City of Albuquerque Stormwater Construction Site Inspection Report

ESC File No.	D10E003A	Project Name:	Tiburon Homes Subdivision		
NPDES Id. No.	NMR1001PP	Location:	Tiburon Hills and Trestle Glen		
7/12/2021	Owner	Contractor			
Operator	Rhett Ashley Homes	Rhett Ashley Homes			
Contact name & title	Rhett Waterman	Mike Fitt			
e-mail	watermanrhett@comcast.net	mikef43@q.com			
Contact Phone #	505-917-6157				
COA Inspector	Thomas Evans	Start/End Time:	9:10 AM-9:20 AM		
Construction Phase:	Home construction				
Type of Inspection:	☒ Regular	☐ Storm Event	☐ Past Storm Event >0.25"	☐ 311/Complaint	
				☐ Follow Up	
Weather at time of inspection?	clear	Temperature:	~	74	
Estimated date of last storm 0.25" or greater	7/6/2021

TEMPORARY EROSION AND SEDIMENT CONTROL PLAN

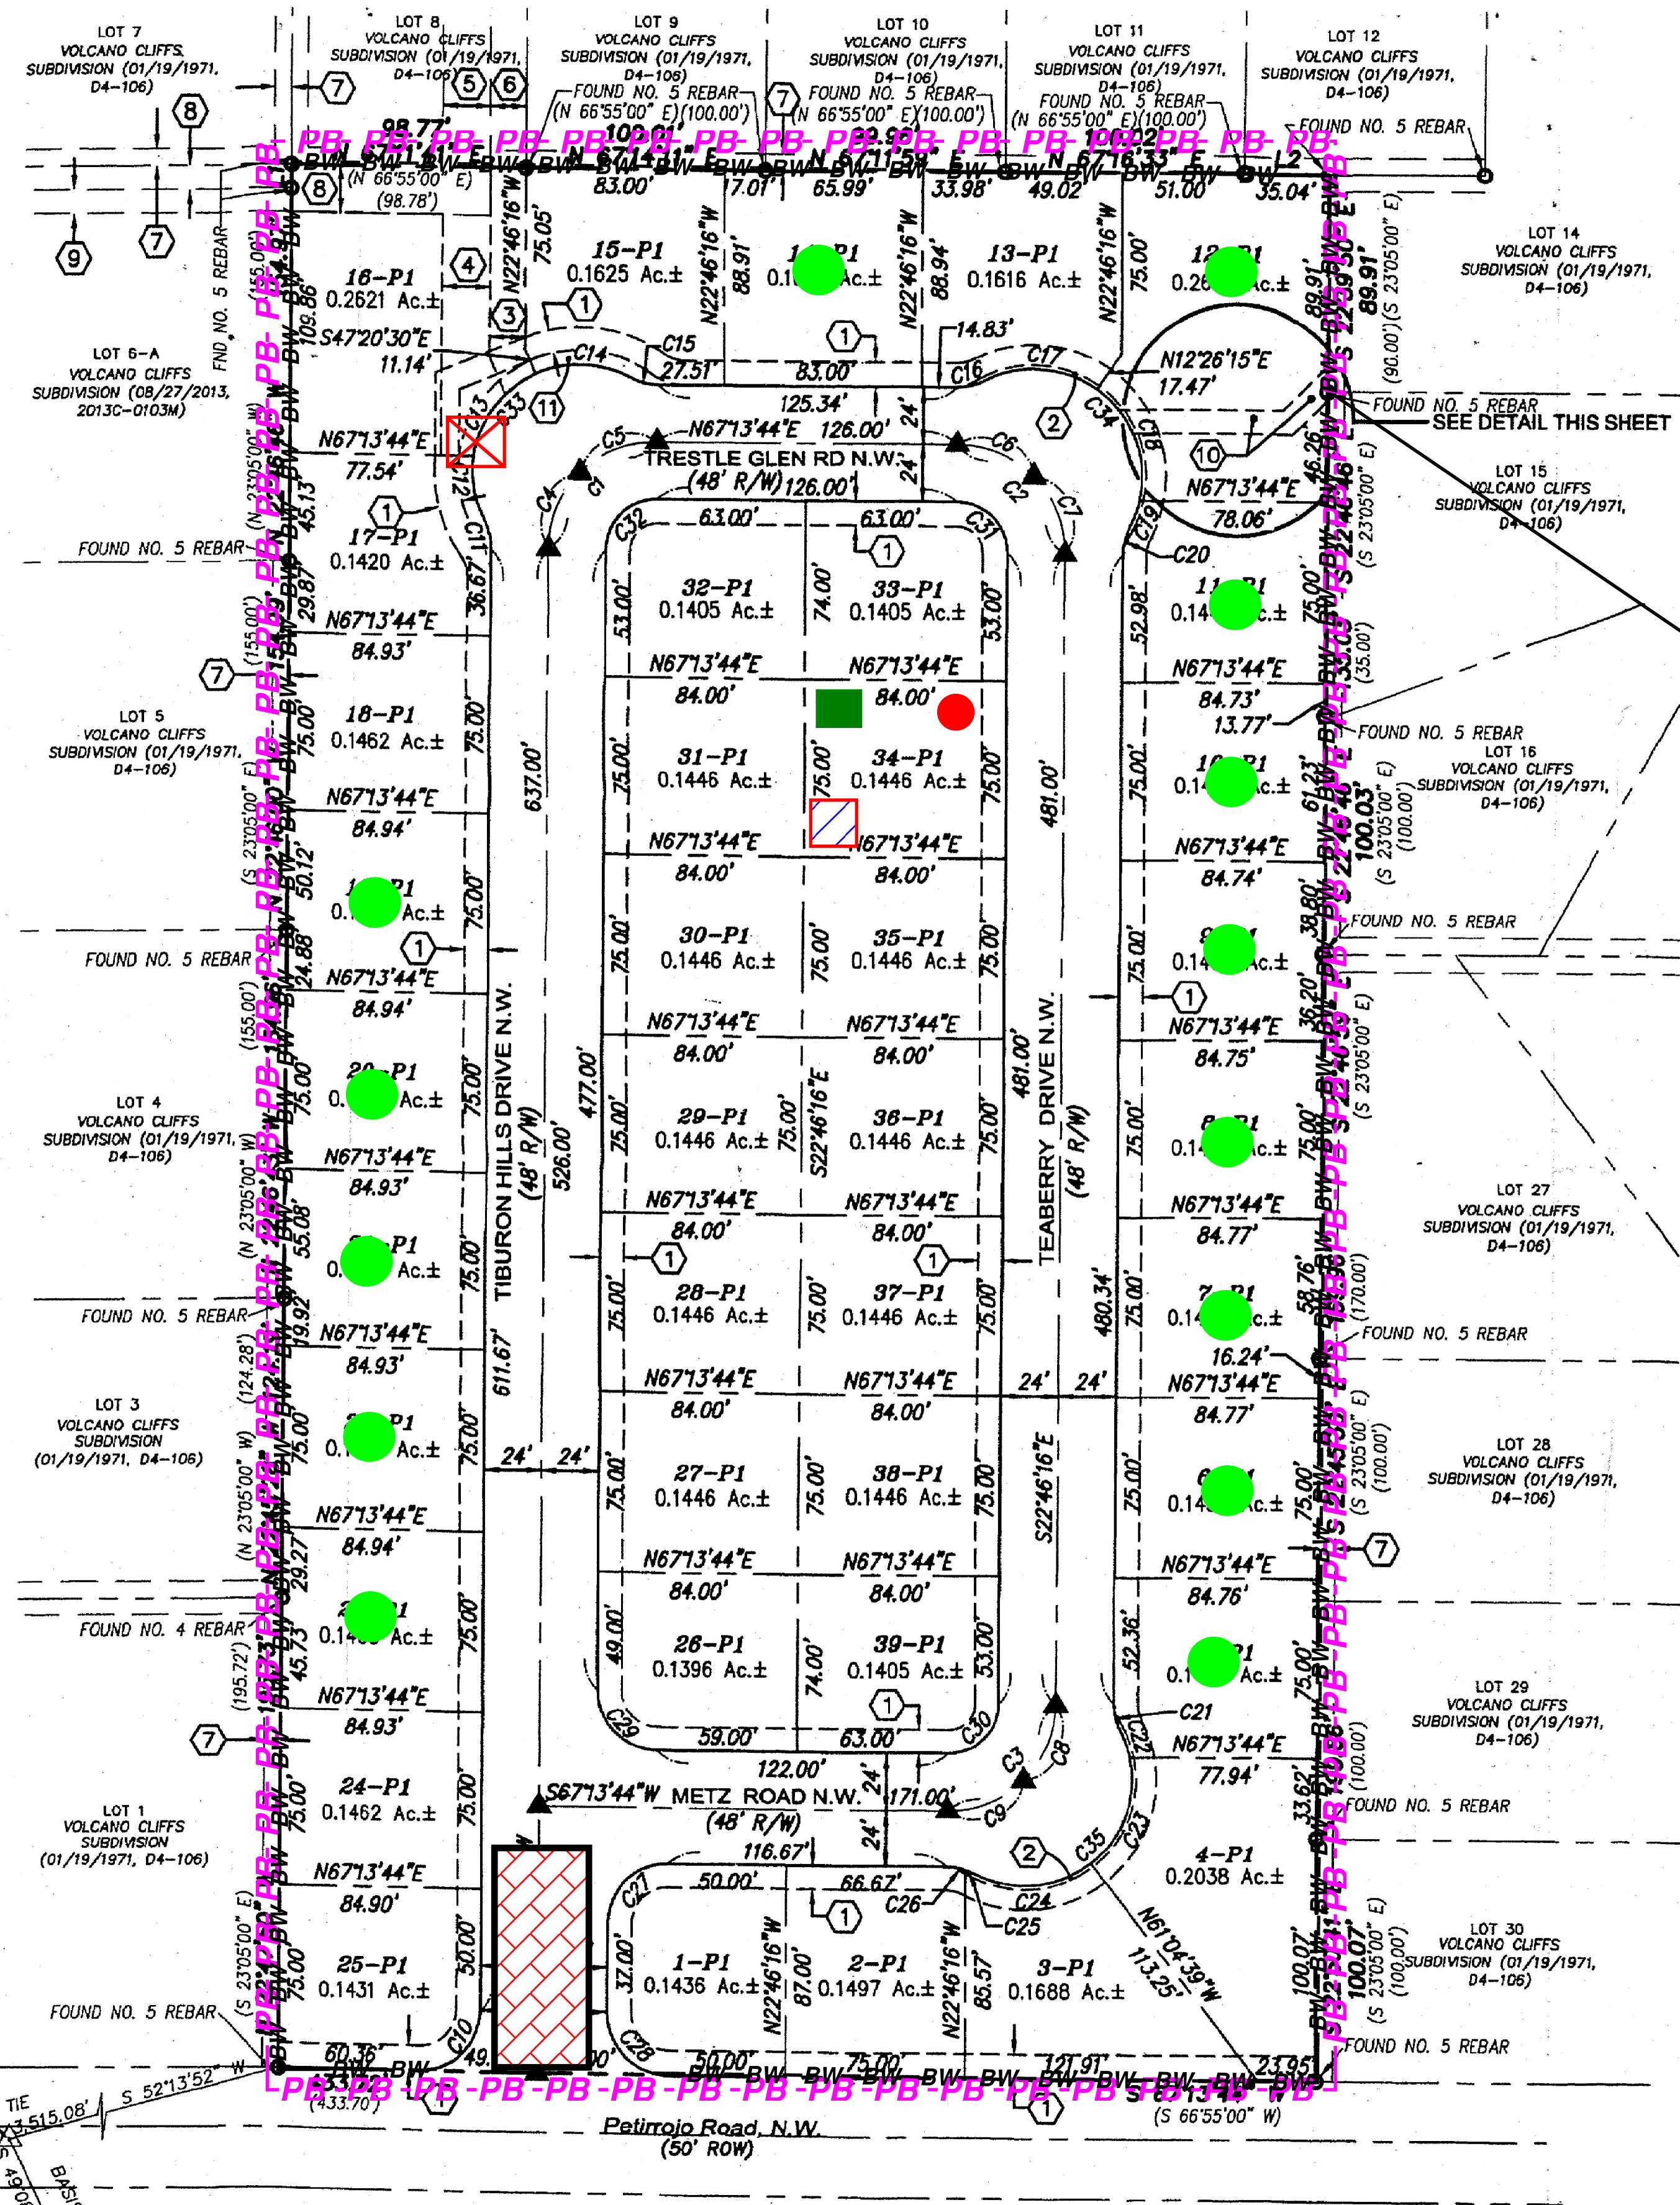
Item Number	Deficiency/ Corrective Action				
1	Posting of permit coverage was down. Properly erect posting.				
2	Sediment on the sidewalks. Maintain cut-backs and sediment controls to prevent sediment from getting on the sidewalks and in the street.				
3					
4					
5
